Application by Net Zero Teesside Power Limited and Net Zero North Sea Storage Limited for an Order Granting Development Consent for the Net Zero Teesside Project

Please find enclosed a written representation submitted on behalf of EDF Energy Renewables Limited and Teesside Wind Farm Limited ("**EDF**") in respect of the above application.

Plot Date: 21 April 2022 09:48 Tille Name: C:\Users\NicHArdent Management Ltd\Ardent Management Ltd\Proiects - P16 - GIS & CAD Files (2)\026 ABDG TCCC\MXD\Land Plan;

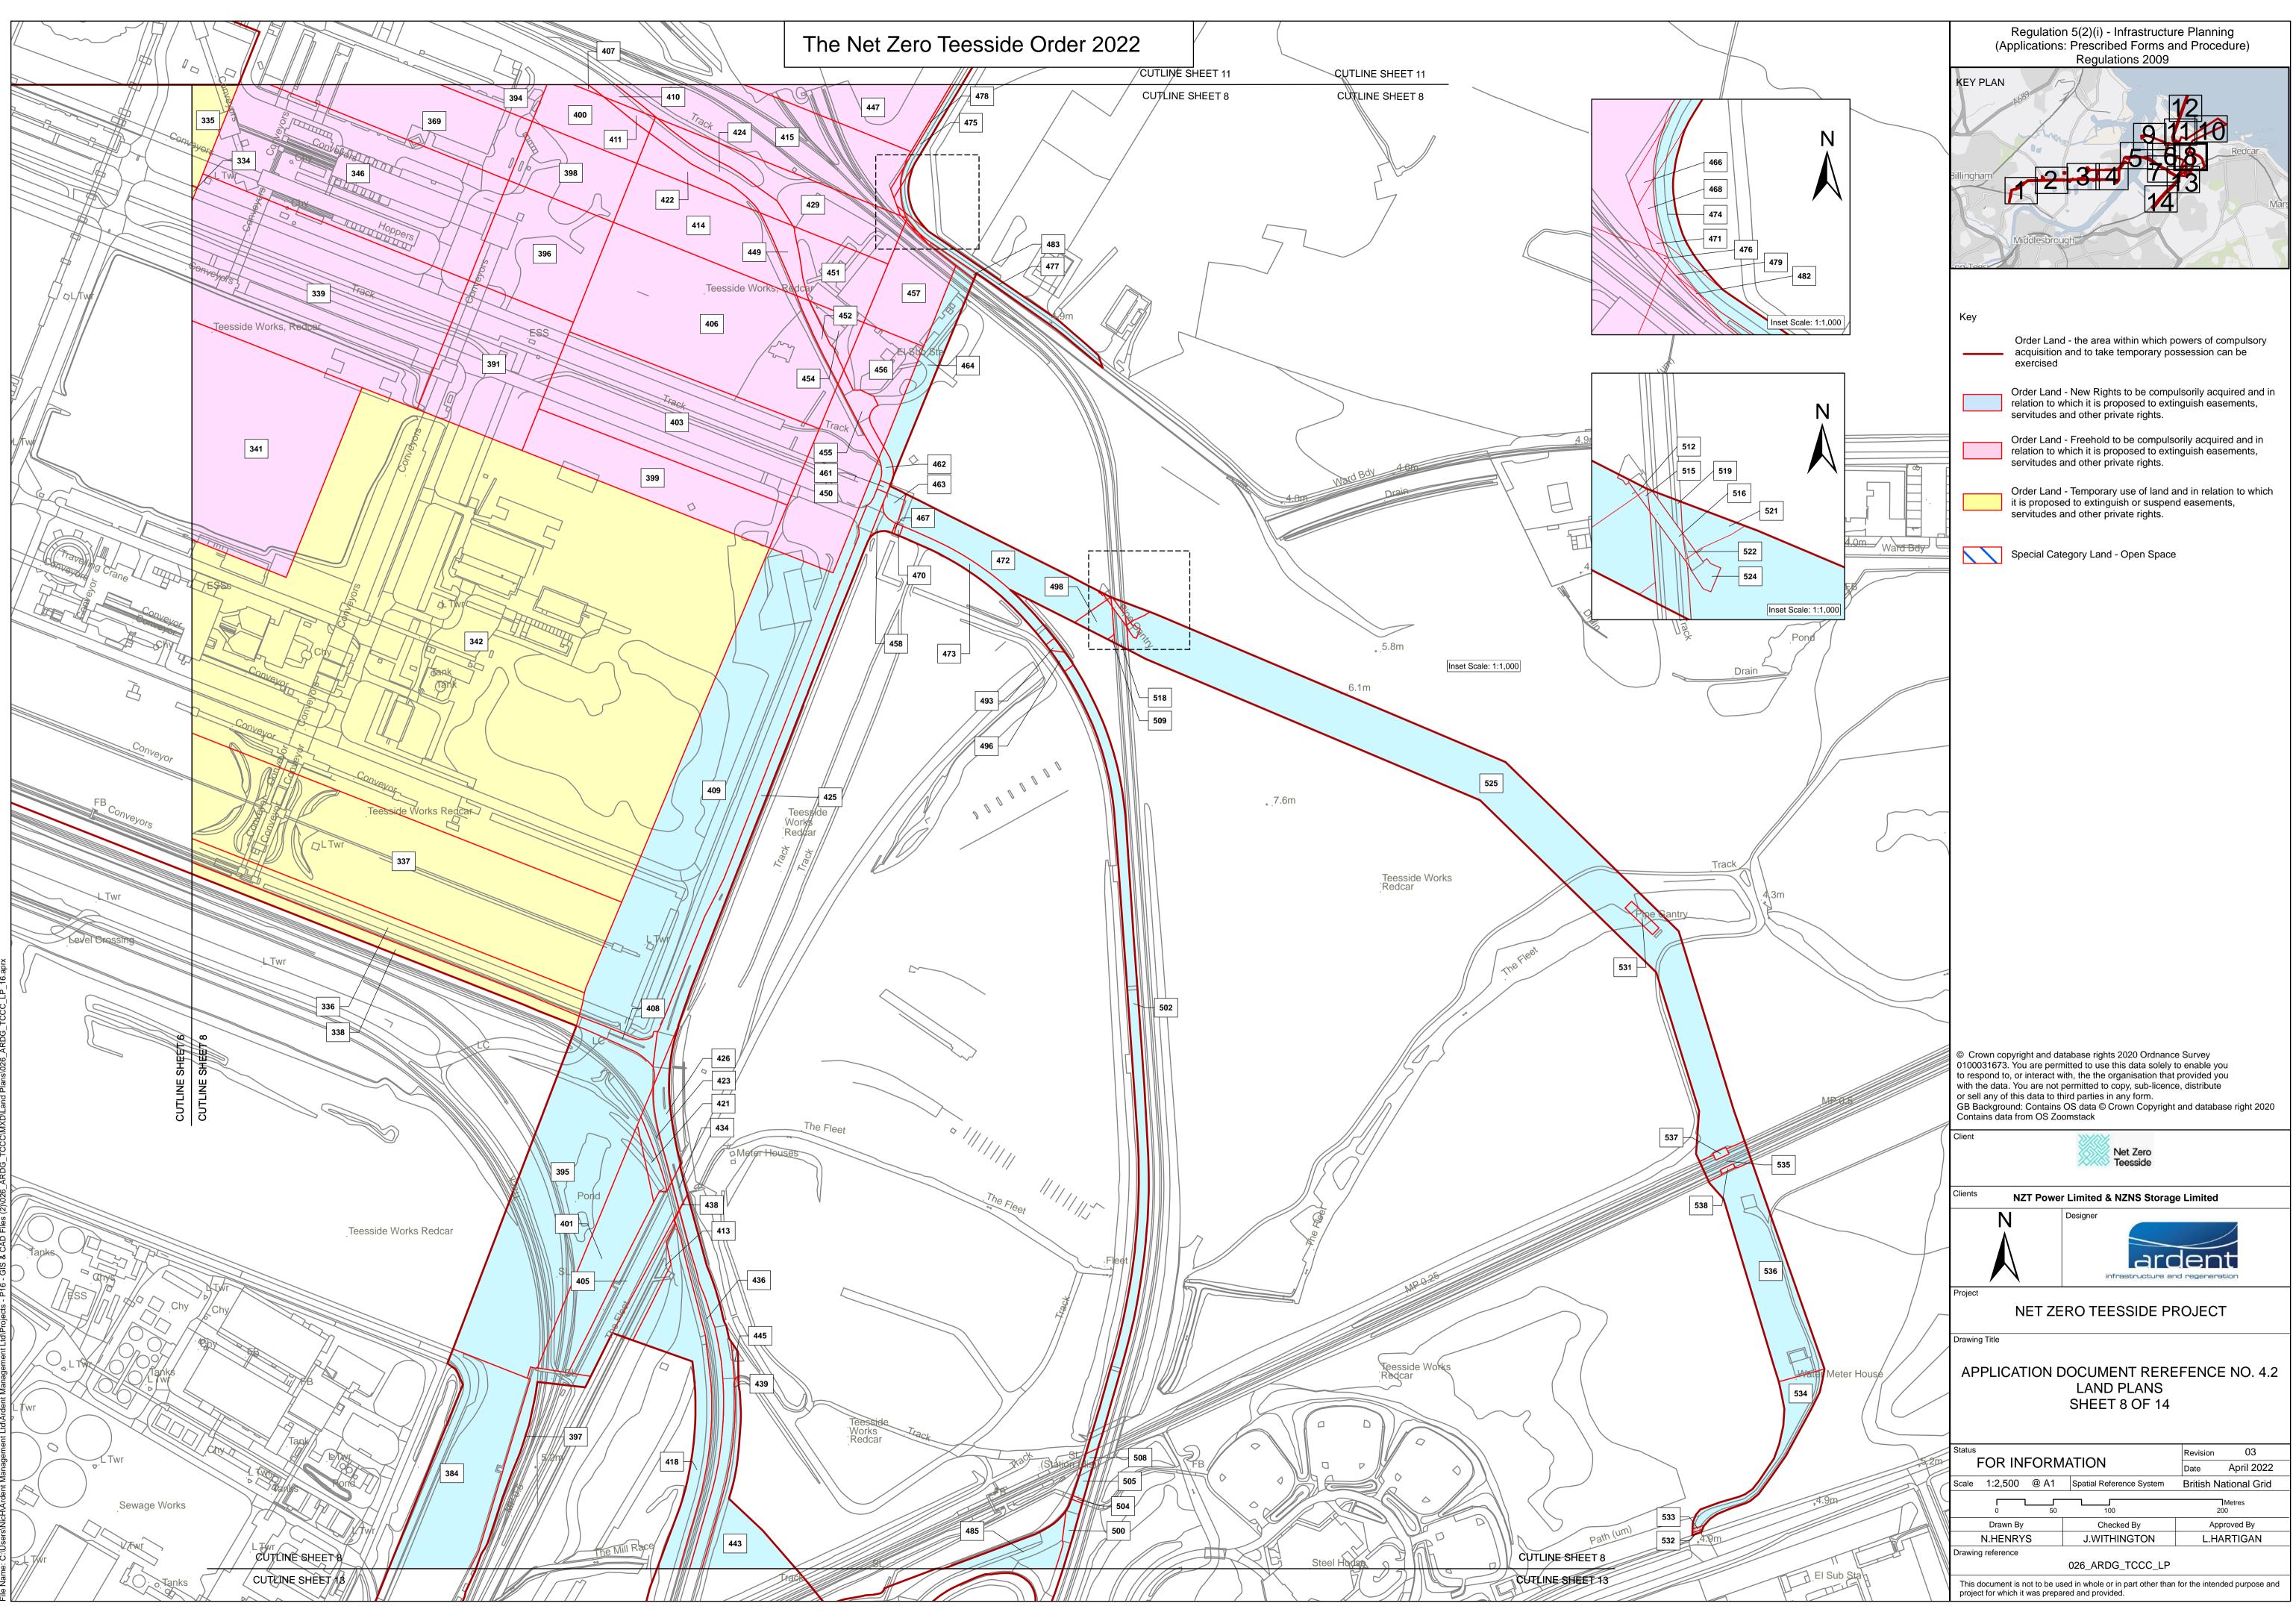
- Work No. 5 – wastewater disposal works in connection with Work No. 1, comprising—
(a) Work No. 5A – repair and upgrade of the existing water discharge infrastructure to the Tees Bay; or (b) Work No. 5B – a new water discharge pipeline to the Tees Bay; and (c) Work No. 5C – up to two new wastewater pipelines between Bran Sands Wastewater Treatment Plant and Work No. 1.
- Work No. 8 – high pressure carbon dioxide export pipeline corridor, comprising an overground and underground pipeline of up to 800 millimetres nominal bore diameter and associated power and fibre-optic cables.

These Works are shown on Sheets 10 and 12 of the Land Plans.

As a result of those discussions, EDF is concerned that the above Works may cause the following issues for the operation of Teesside Wind Farm:

1. Risks associated with vessels in close proximity to EDFs offshore turbines (during construction or maintenance).
2. The risk of any explorations or construction works damaging EDF's offshore cable connection, in particular but not limited to any bore holes that may be drilled in close proximity to EDF's offshore electricity connection.
3. Impacts associated with changes to the seabed that may impact upon the foundations of the offshore turbines.
4. Seismic effects that may result from the proposed works that may impact upon the stability of the offshore turbines foundations.

EDF are seeking to arrange an urgent meeting with the Applicant regarding protective provisions within the draft Development Consent Order to address the above matters, on which it is hoped that a conclusion will be reached shortly. To the extent agreement cannot be reached, EDF will maintain its objection to the draft Development Consent Order in relation to these matters.
